Application No: AB/49/22/HH
Site Address: 31 Tarrant Wharf Arundel BN18 9NY
Description of works: Erection of single storey rear extension including the installation 2 x rear balconies and side rooflight and alterations to fenestration. This application may affect the character and appearance of the Arundel Conservation Area.

Thank you for your internet representation made on 21st May 2022 which has been recorded as an objection with the comments as follows:

DRAWING TITLE
 PROPOSED FLOOR PLANS,
 SECTION AND ELEVATIONS

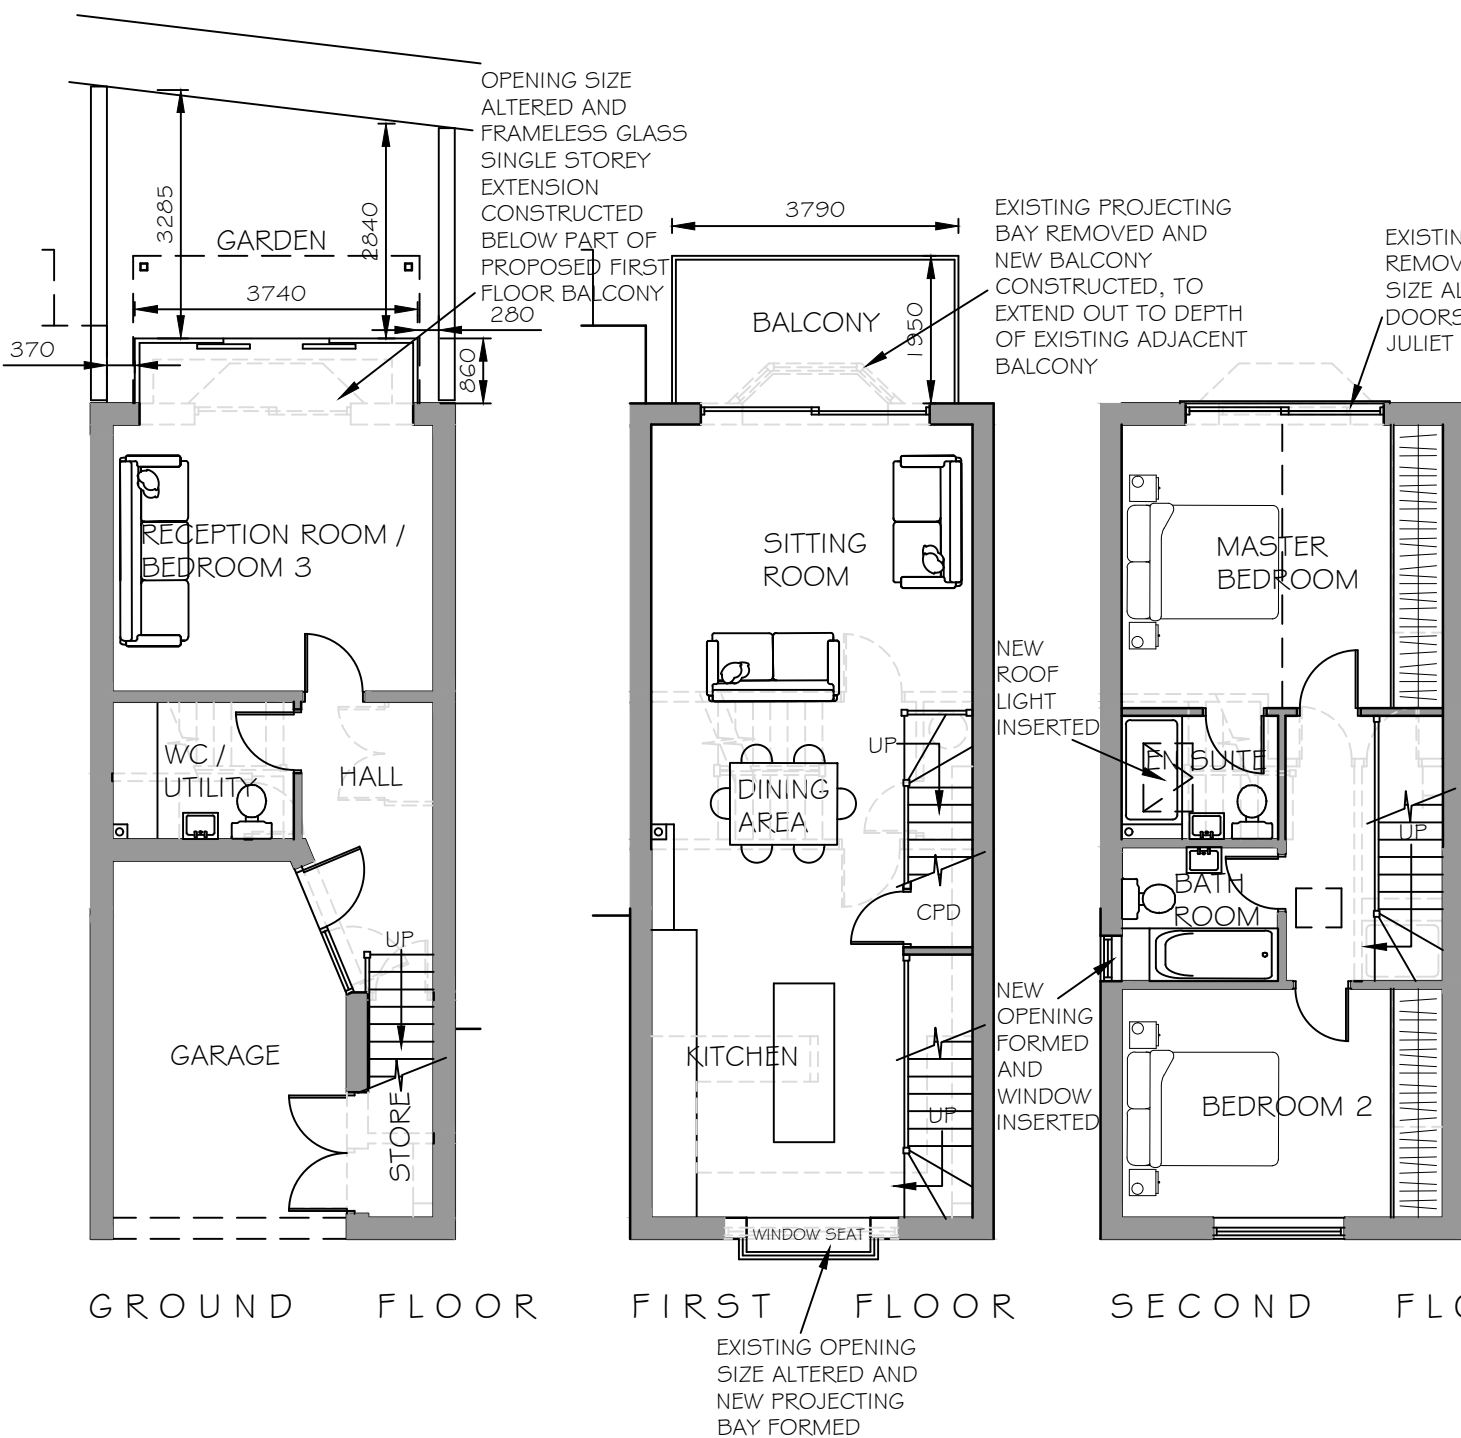
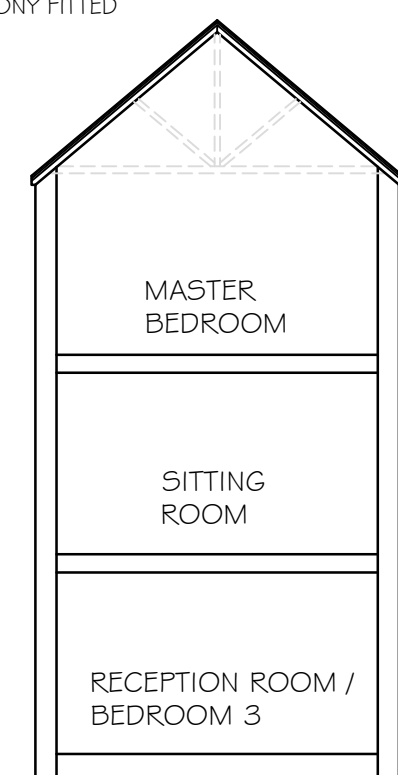
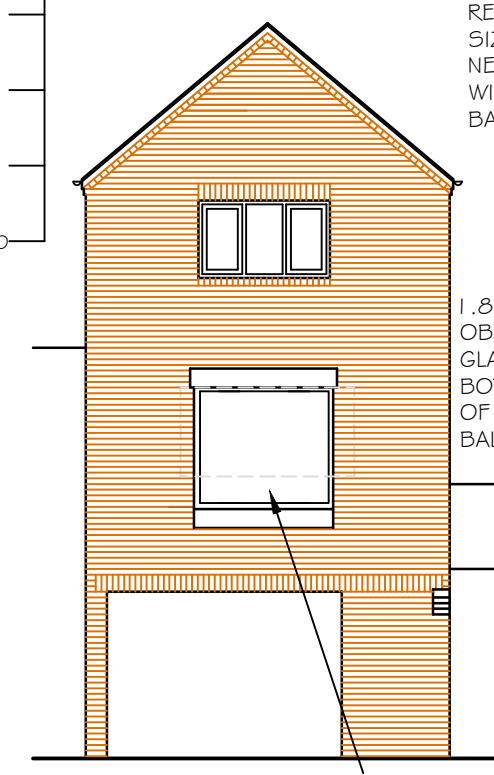
Following on from my earlier comment regarding the proposed obtrusive and enlarged rear balcony, I would like to confirm that these houses are part of the Arundel conservation area and the proposed rear balcony, beside being overly large, would be out of keeping visually with the existing balconies of the houses each side in terms of design shape and materials used.
